Our ref: DOC22/233283
Your ref: SSD-12346552

Greater Western Battery Energy Storage System – EIS Exhibition

Thank you for your e-mail dated 2 March 2022 to the Biodiversity, Conservation and Science Directorate (BCS) of the Department of Planning and Environment (DPE) inviting comments on the Environmental Impact Statement (EIS) for the Greater Western Battery Energy Storage System.

BCS has reviewed the Biodiversity Development Assessment Report (BDAR) for the project. Our biodiversity recommendations are provided in **Attachment A** and detailed comments are provided in **Attachment B**.

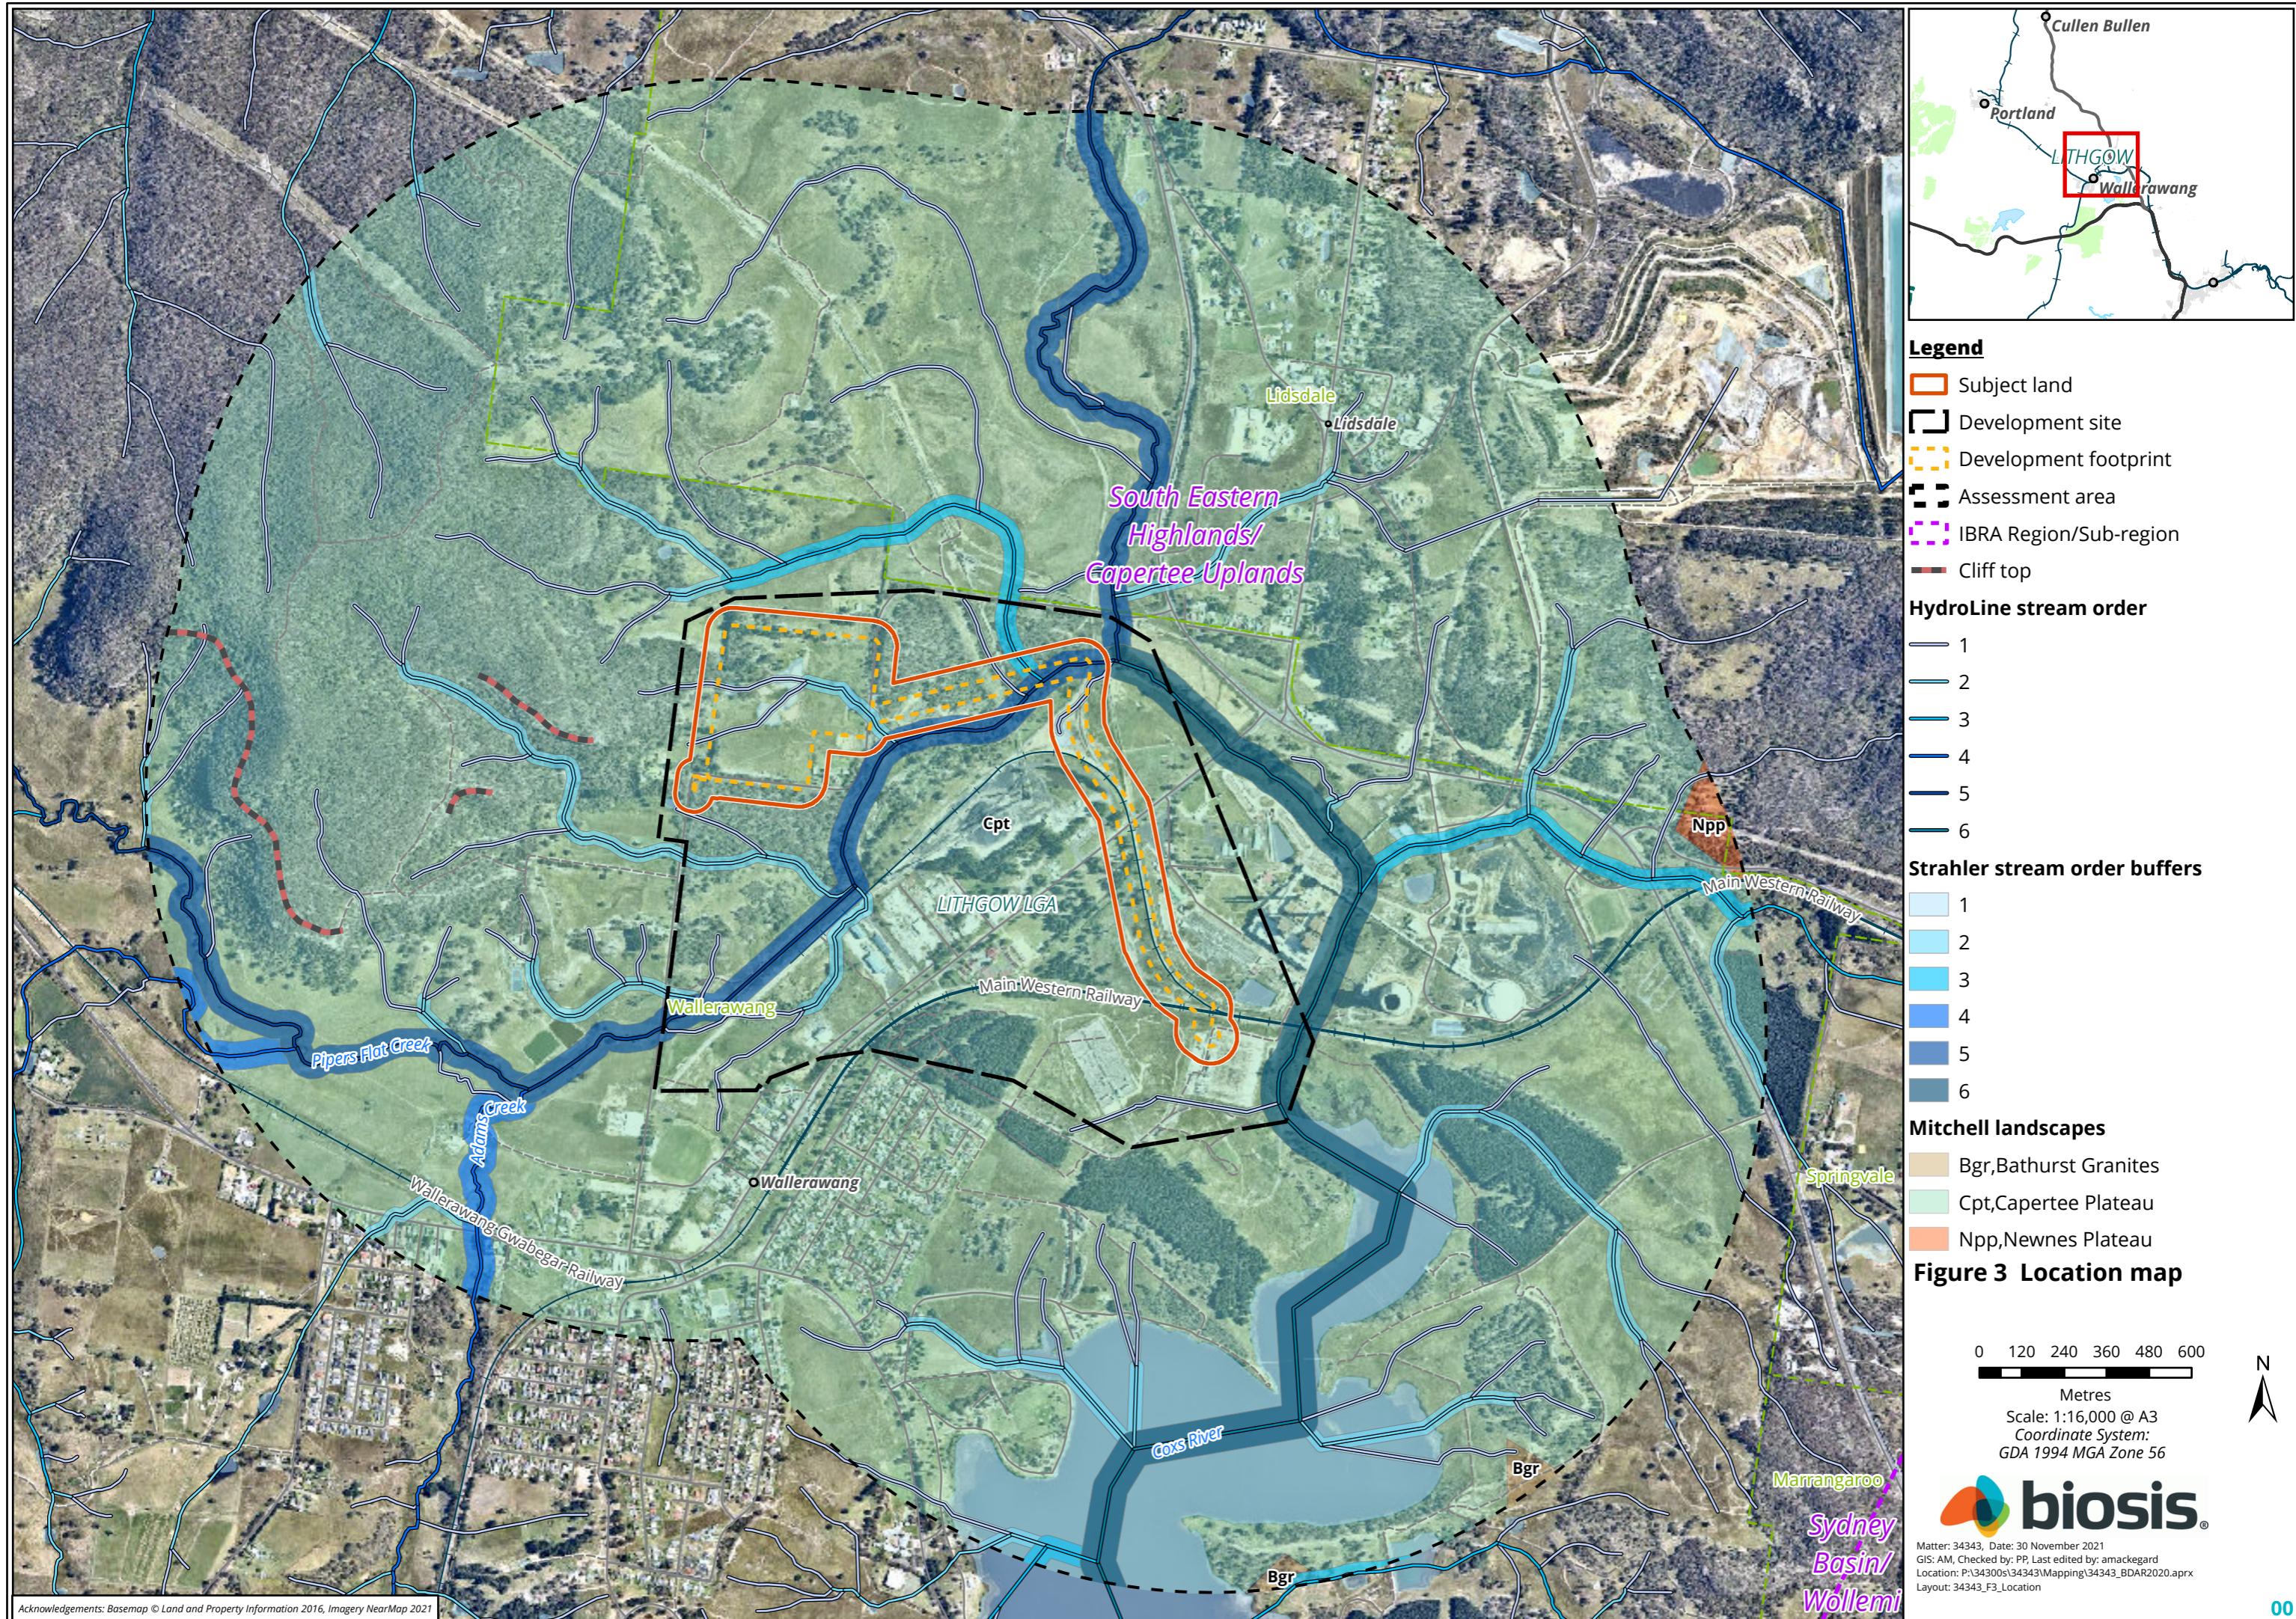
3. The mapping of native vegetation extent requires consistency between Figures 4 and 5 of the BDAR and the vegetation cover class estimate requires revision

In addition, areas of native vegetation extent (derived native grassland) have been excluded from Figure 4 of the BDAR and the landscape vegetation assessment despite these areas being identified within the subject site's native vegetation extent mapping in Figure 5.

The assessor should note that, native vegetation extent identified and mapped within the subject site (inclusive of both woody and non-woody native vegetation) is required to be included within the native vegetation cover polygon on the landscape assessment map and the vegetation % cover class assessment (Section 3.2 of the BAM 2020).

The assessor should undertake finer scale vegetation extent mapping and include both woody and non-woody vegetation, in accordance with the requirements set out within Section 3.2 of the BAM 2020.

3.1. Undertake finer scale vegetation extent mapping and include both woody and non-woody vegetation within mapping
